TOWN AND COUNTRY PLANNING ACT 1990 PRIOR NOTIFICATION

Reference: H17-0485-25 **Date of Decision:** 15th July 2025
Applicant: Mr H Brown
The Chestnuts
Reservoir Road
Surfleet
Spalding
PE11 4DH
Location: Rear Of The Chestnuts Reservoir Road Surfleet Spalding
Description: Conversion of agricultural building into dwelling

Drawing No: 22/621/PA/012A

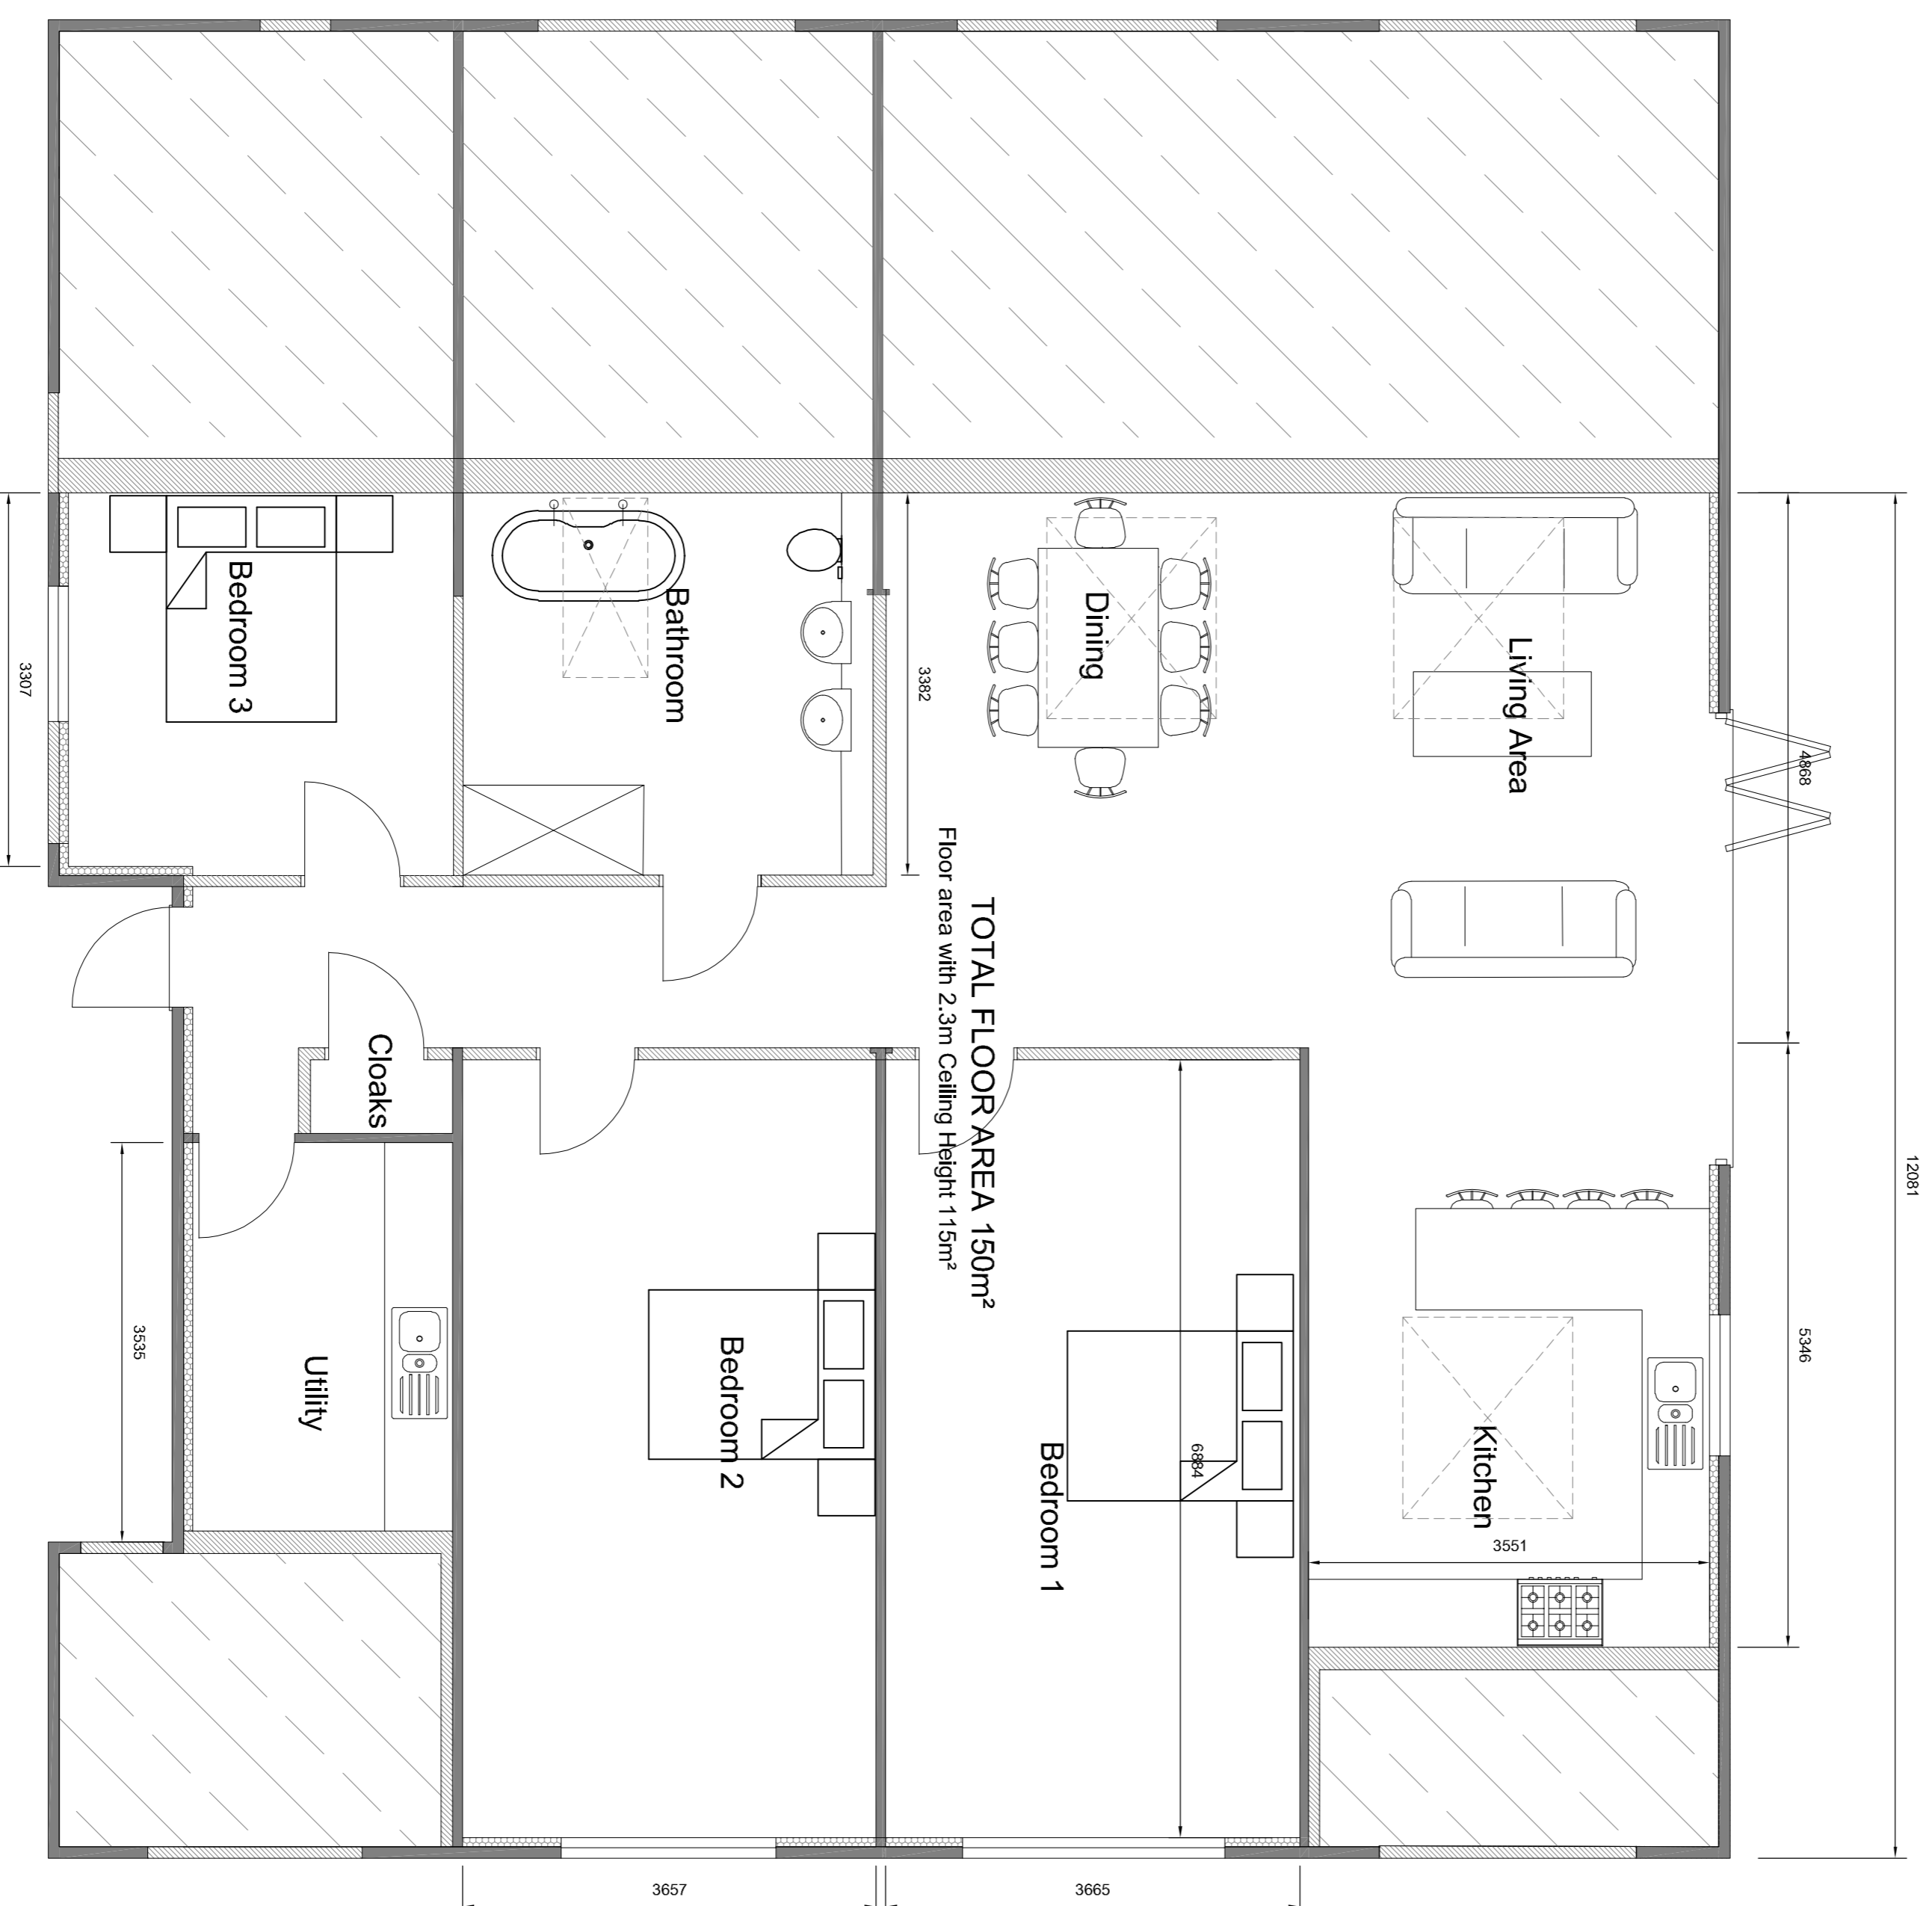
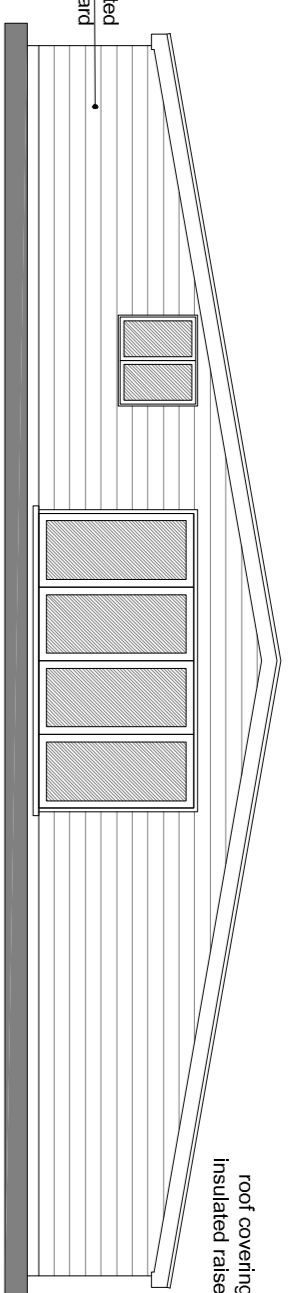
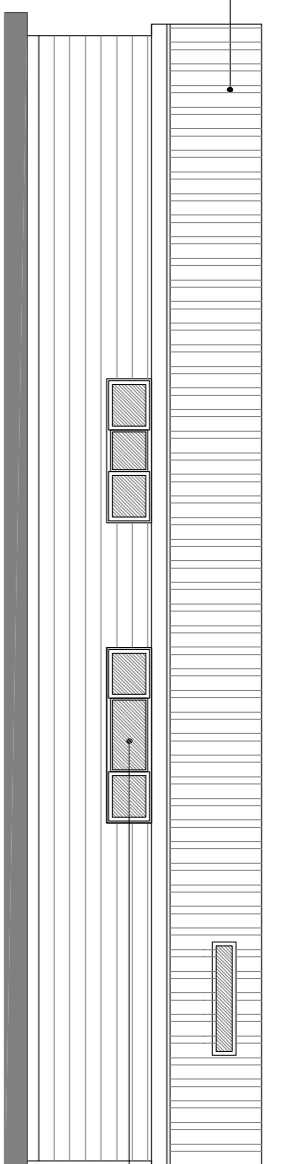
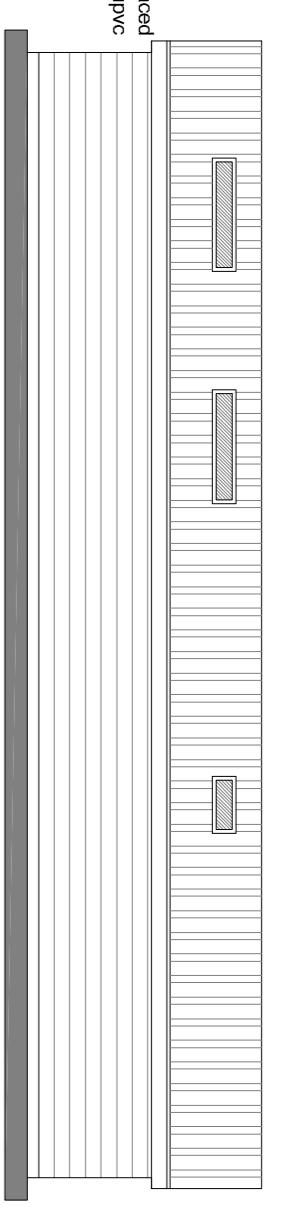
- 1 The building is located in Environment Agency Flood Zone 1; however, the surrounding land and access road is located in Flood Zone 3. Furthermore, the SFRA states that the building is in an area that is a "Danger for Most" hazard area, which has a Hazard Depth of 1.25m - 2m. In such areas the South Lincolnshire Standing Advice Matrix, in line with the Environment Agency, requires a minimum of two floors and potentially increased finished floor levels.

The application is not supported by information surrounding flood depth associated with this site. The South East Lincolnshire SFRA forms the basis of this assessment. Without this level of information, it cannot be established that the proposed dwelling would be safe for its lifetime in the instance of a flood event.

In any event, the level of works that would be required to achieve the necessary flood mitigation to ensure that the scheme exceeds the flood depths, may be such that the

resultant floor to ceiling height would be below the 2.3 metres required under the nationally described space standards, thus preventing the conversion from occurring under Part 3, Paragraph 9A of the General Permitted Development Order, 2015. It is on the basis that the proposed development may present a risk to human life should a flood event occur, with no demonstrable (or potential for) a safe place of refuge should such an event take place.

The proposal is considered to be contrary to policy 4 of the South East Lincolnshire Local Plan and has failed to demonstrate that nationally described space standards can be met, given the insufficient information surrounding flood depths and potential mitigation measures required, especially the need for increased finished floor levels as well providing safe refuge.
